WEST SUSSEX COUNTY COUNCIL CONSULTATION

TO:	Arun District Council (ADC) FAO: Anita Gardner CC:
FROM:	WSCC - Highways Authority
DATE:	16 ^h June 2022
LOCATION:	Wicks Farm The Glasshouse Ford Lane Ford BN18 0DF
SUBJECT:	F/4/22/PL Provision of 14 No staff accommodation units for 56 people and welfare facilities for a minimum of 3 years. This site is in CIL Zone 3 (Zero Rated) as other development.
DATE OF SITE VISIT:	Site/ area known to officer
RECOMMENDATION:	No Objection/advice
S106 CONTRIBUTION TOTAL:

Product Name: Eco Cycle Shelter and Rack

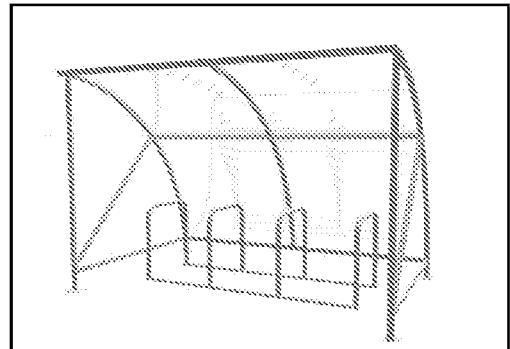
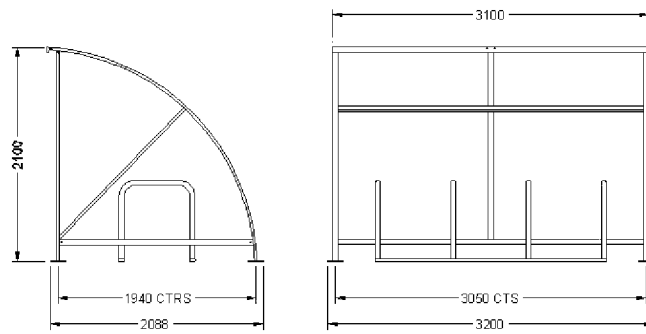
- 1.4 Cycle parking has been shown. No parking spaces have been provided. It is likely that some of these employees will own vehicles. However, this parking will take place on private land off the adopted highway network. It is suggested that some parking for the units is conditioned under the planning application.

1. *Cycle parking* - No part of the development shall be first occupied until covered and secure cycle parking spaces have been provided in accordance with plans and details submitted to and approved by the Local Planning Authority.
